SDNP/20/03581/ADJAUT
Nat Belderson

Neighbouring Authority Consultation

Proposal: Adjoining Authority Consultation from Arun DC, Case Ref: FG/6/20/PL - Development of Animal Rescue Centre, to include new buildings for reception, training & education, cattery, kennels & associated ancillary accommodation, conversion of existing barn into staff accommodation along with driveways, car parking & landscaping. This application is a Departure from the Development Plan.

Address: Hangleton Farm Livery Stables, Wadars Animal Rescue Centr, Hangleton Lane, Ferring , BN12 6PP

WILDLIFE REHABILITATION UNIT
Floor Plan 1:100

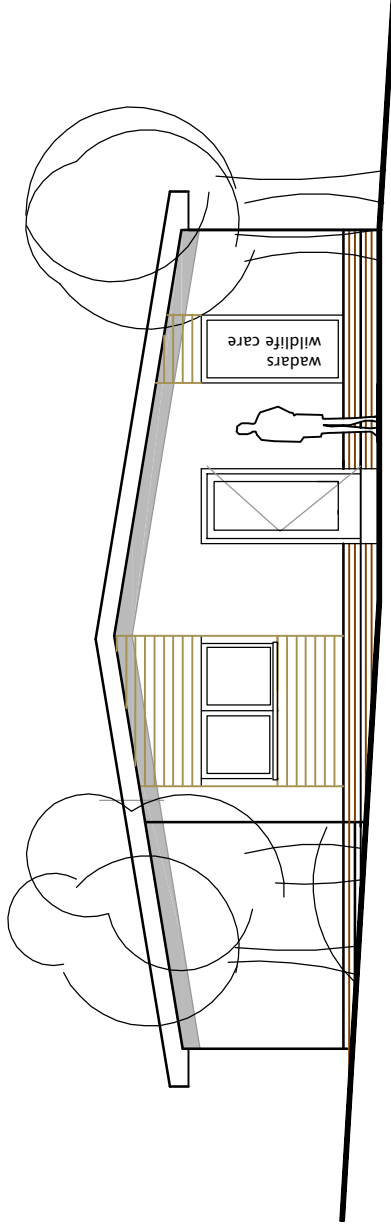
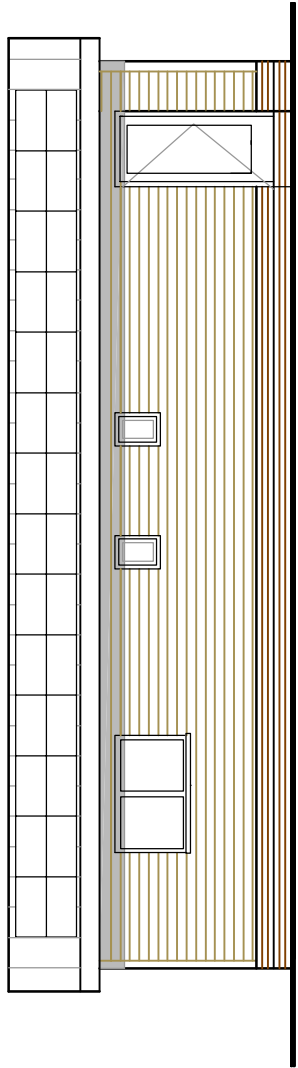
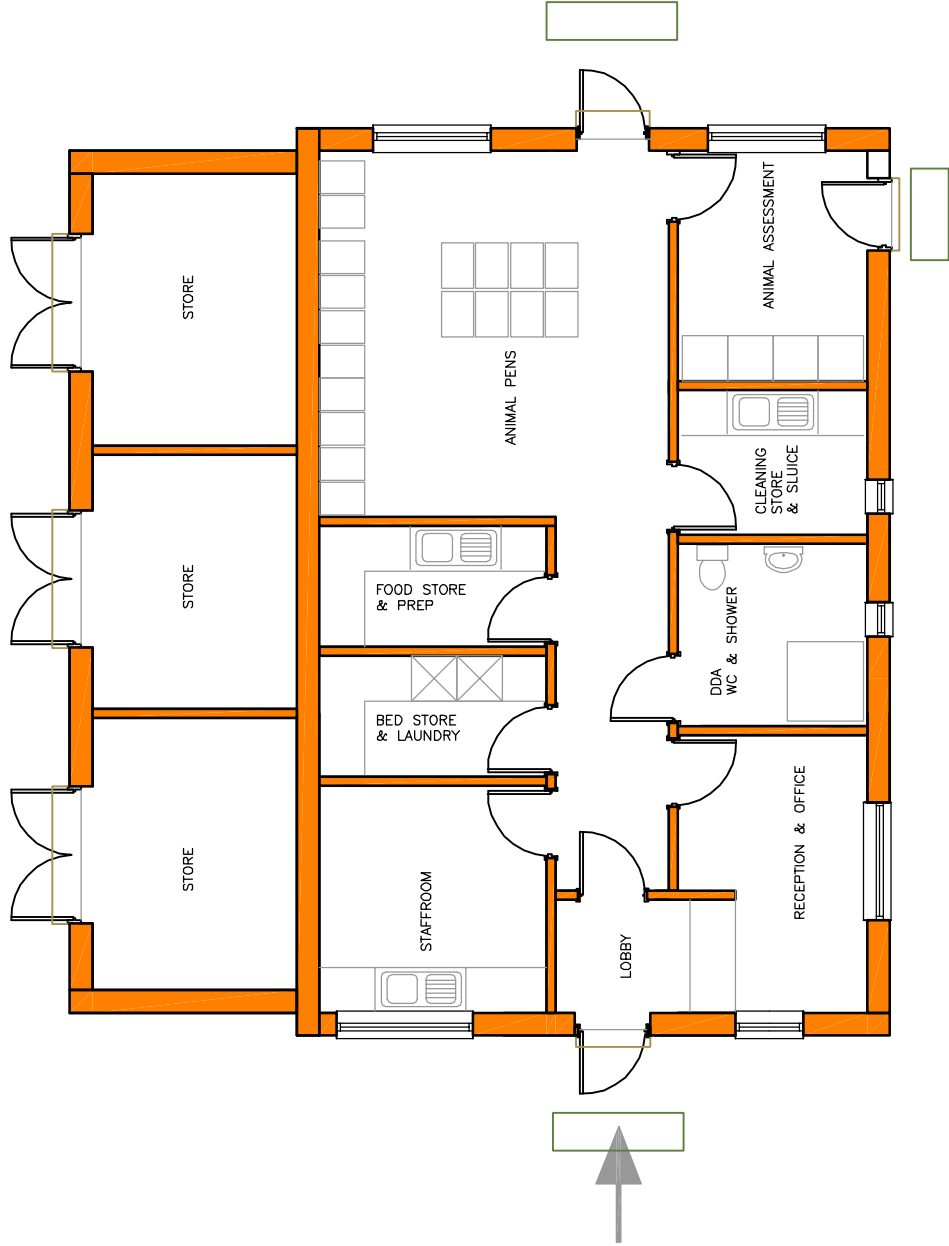
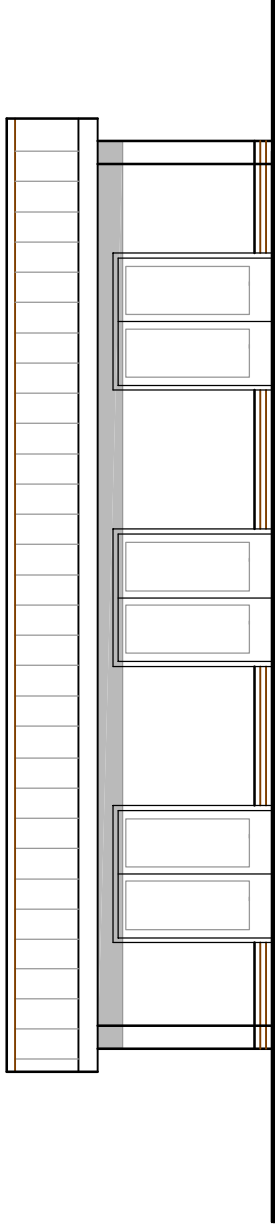
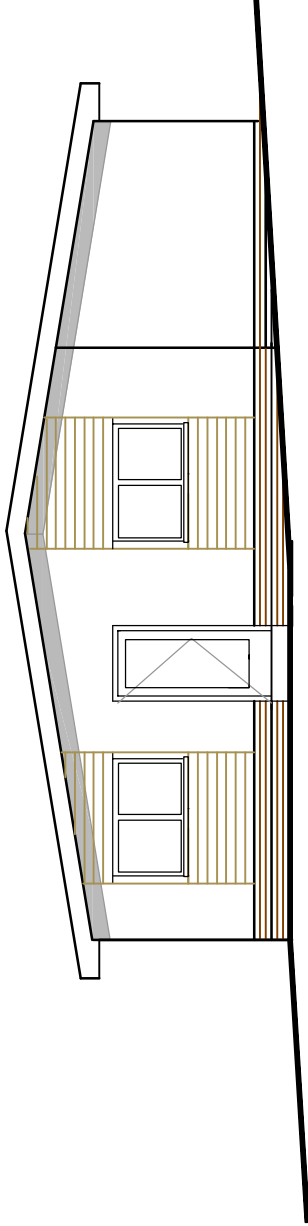
The proposal raises concerns in terms of extending built development further east away from Hangleton Lane, with the wildlife rehabilitation unit and its access road being particularly disconnected from existing development. The Site Plan does not indicate whether changes are proposed for the paddocks further east, although it shows the use of 1.8m high mesh fencing which may not be appropriate in this rural area. There may be an opportunity to partly offset this through a reduction in the ranch-style fencing currently in place.
